**RE: BEK Distribution Facility
601 Gallatin Place NW
Grading and Drainage Plan & Drainage Report
Engineer's Stamp Date: 09/06/19
Hydrology File: J10D002G1**

Based upon the information provided in your resubmittal received 09/06/2019, the Grading & Drainage Plan and Drainage Report are approved for Building Permit, Grading Permit, and for action by the DRB on Site Plan for Building Permit.

RE: **BEK DISTRIBUTION FACILITY – 601 GALLATIN PL. NW
D&D PLAN AND DRAINAGE REPORT ENGINEERS
STAMP DATE 07/19/2019, HYDROLOGY FILE: FJ10D002G1**

OVERALL
GRADING PLAN

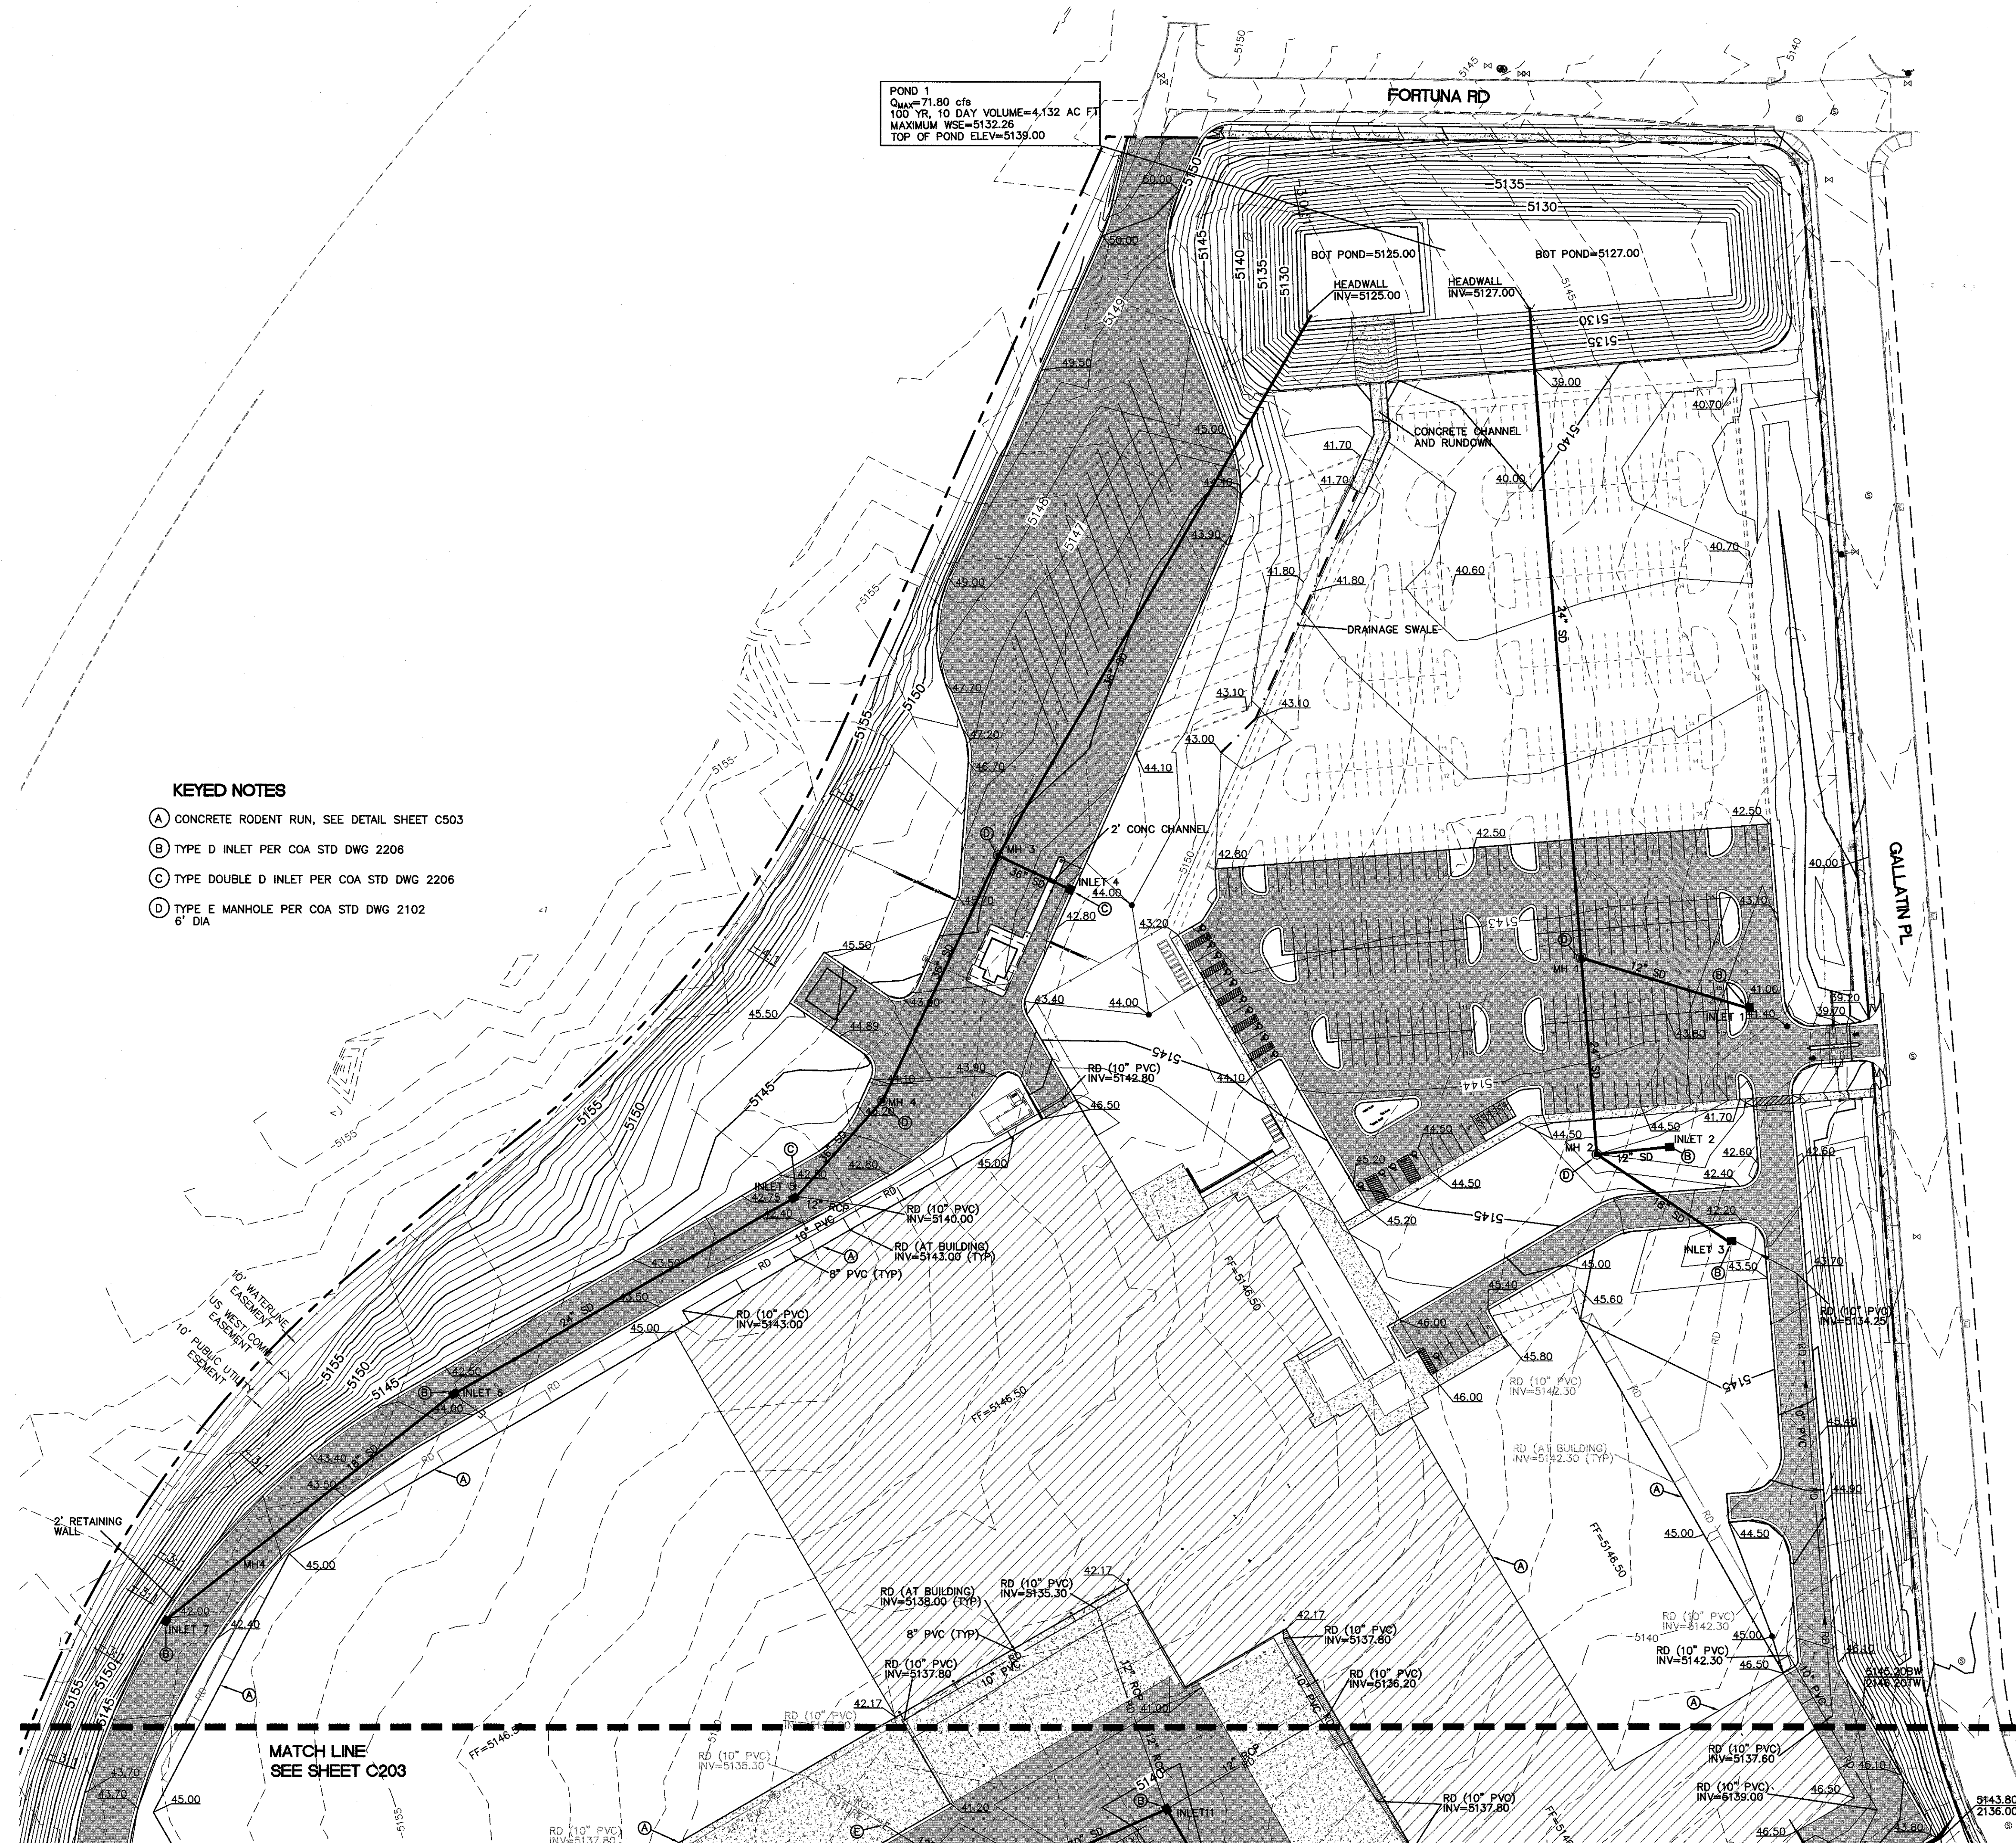
6. Please label the contours in the north east corner of the parking lot and verify that the spot elevations agree with the contours. If they are not 5141 and 5142 then please revise the grading to decisively contain the parking lot drainage and convey it into the north pond.

7. The contours indicate erratic slopes varying from 1% to 10% with abrupt grade changes in the northwesterly 250' of the staging/parking lot. Please revise the grading.

Response: The noted contours (5141 & 5142) are now labeled and the parking lot drainage is conveyed into the north retention pond on Sheets C201 & C202.

Response: The contours were corrected to reflect proposed, non-erratic slopes in the noted staging/parking lot on Sheets C201 & C202.

Revision No. _____
Job No. 2018014
CAD/CHK'D By. pm / vc
Date 7-19-19
Sheet Title
Sheet No. C202
CIVIL

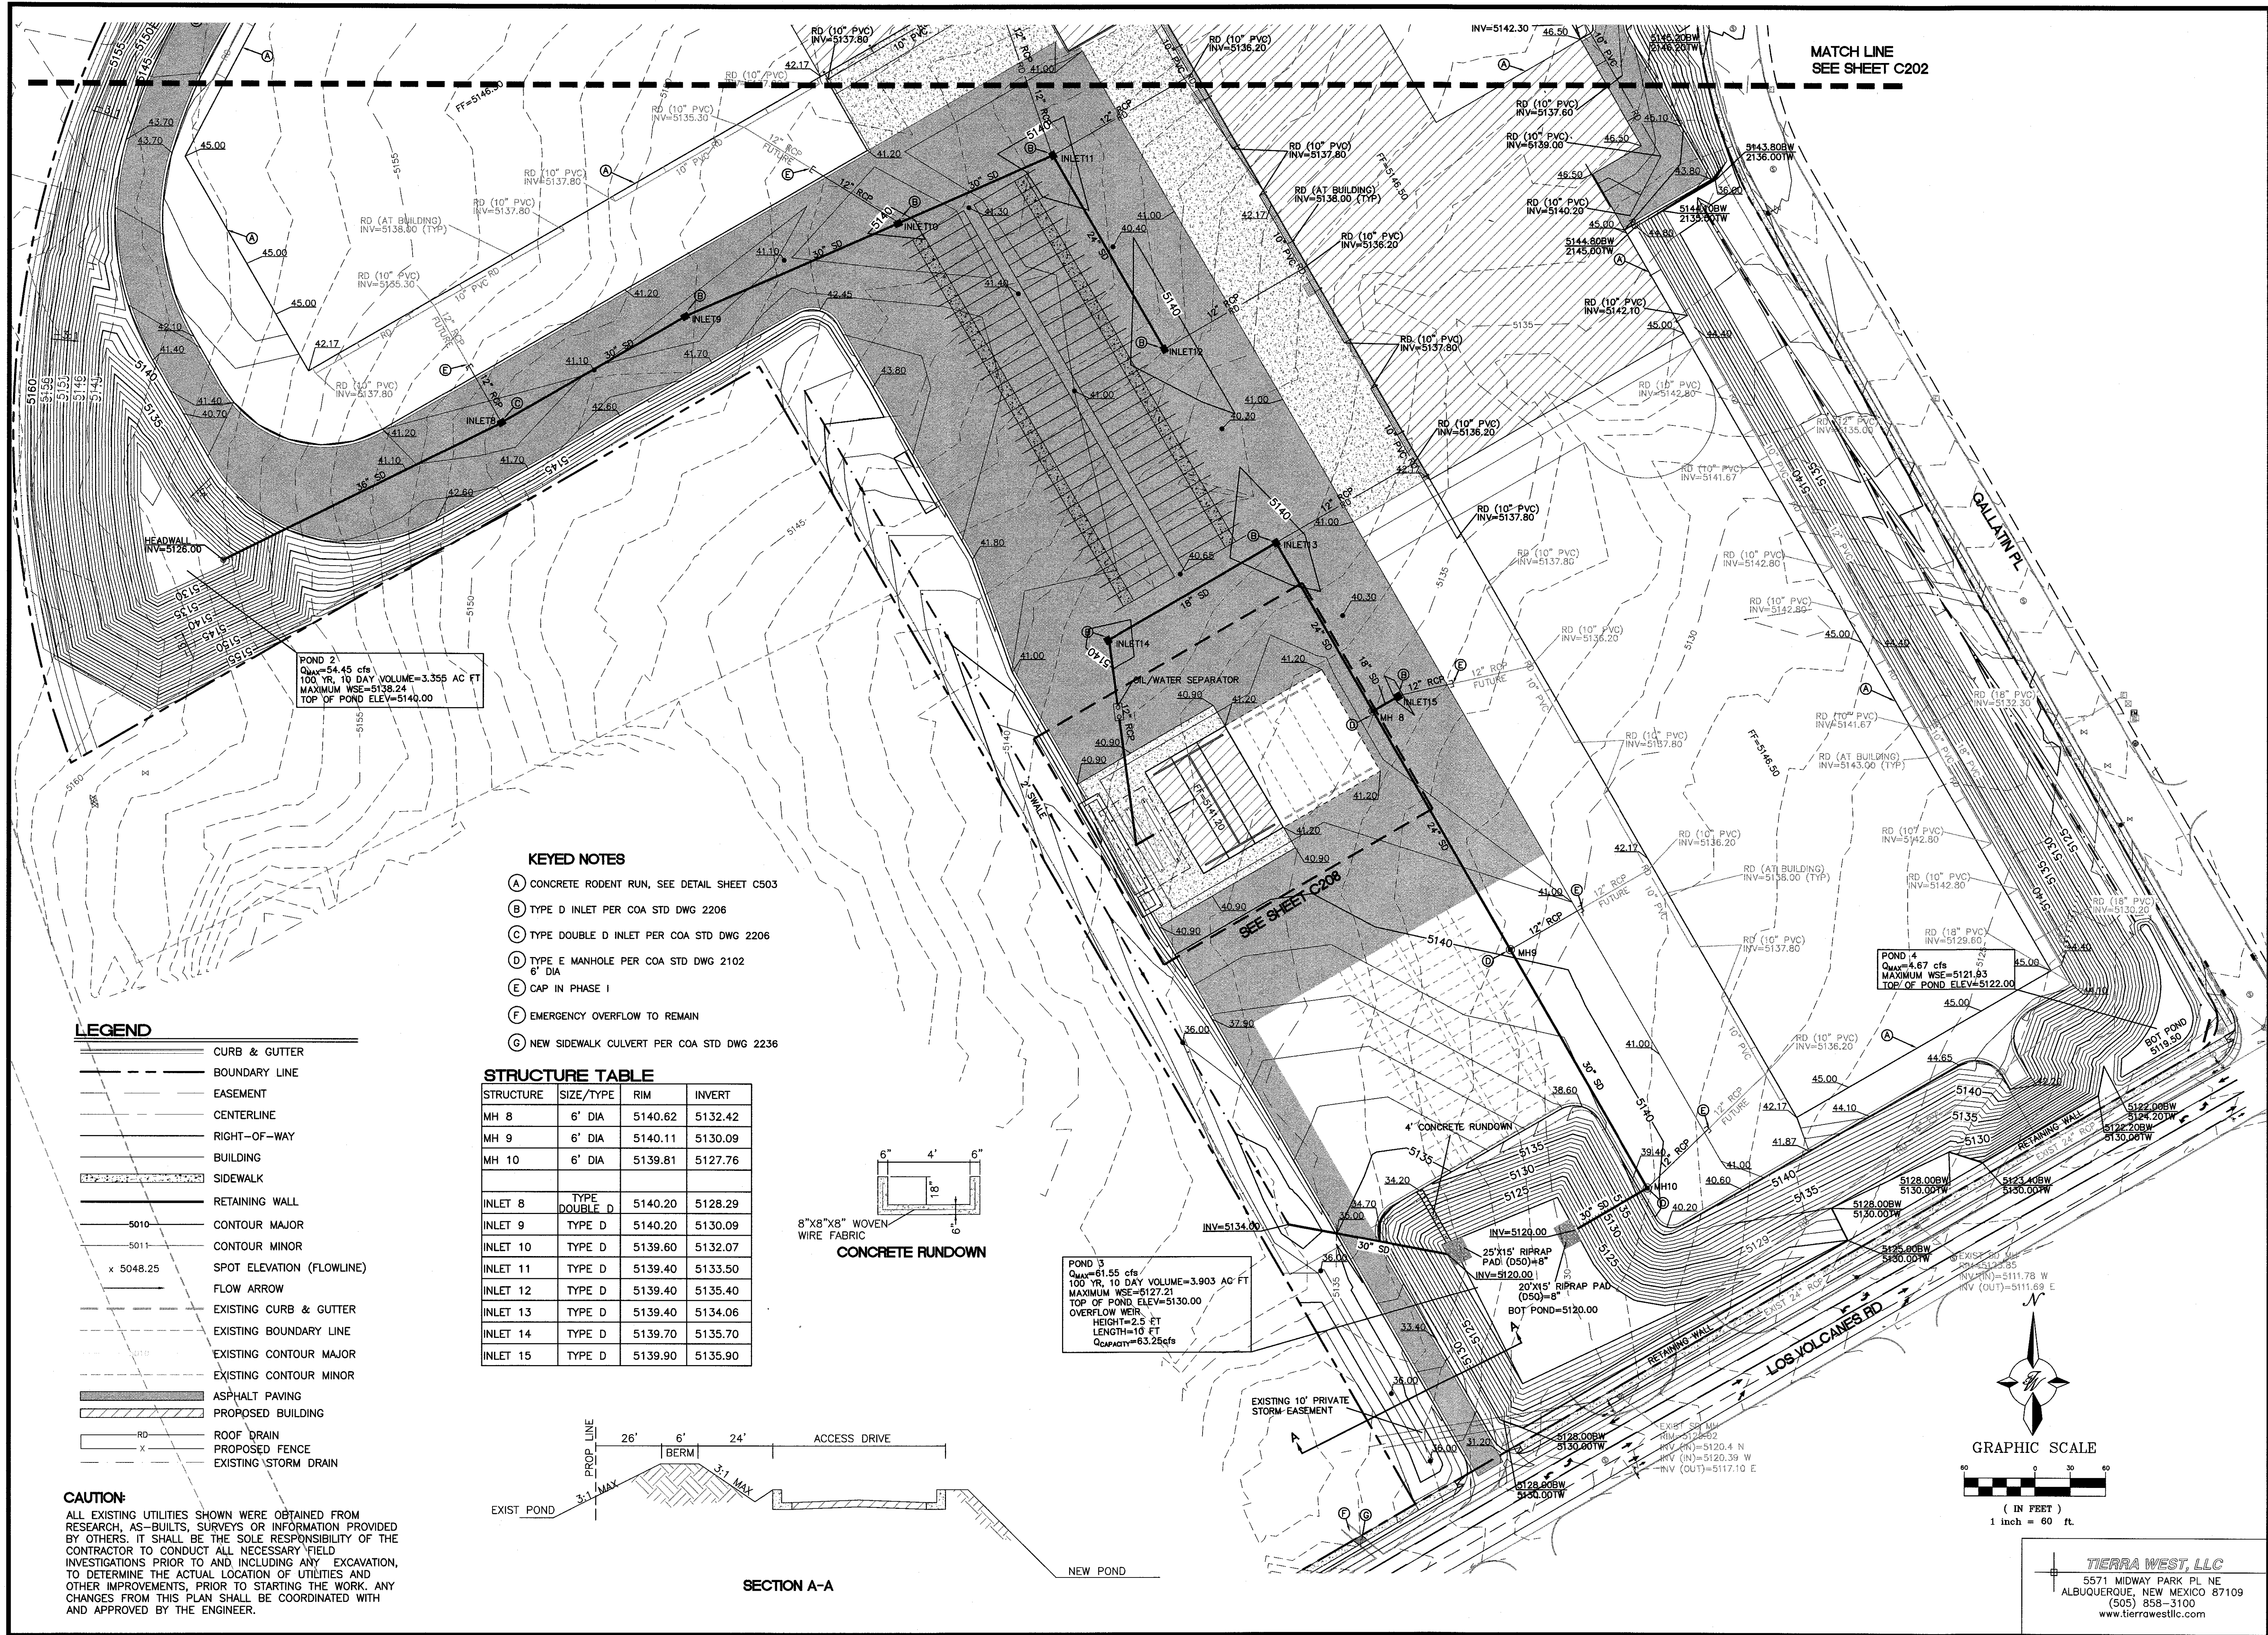
4. How will drainage get out of the sump in the C&G on the east side of the Staging area?

Response: A 2ft curb cut and erosion pad were added to the proposed curb in the staging area will allow the drainage to continue east to the proposed swale and concrete rundown into the north retention pond, see Sheet C202.
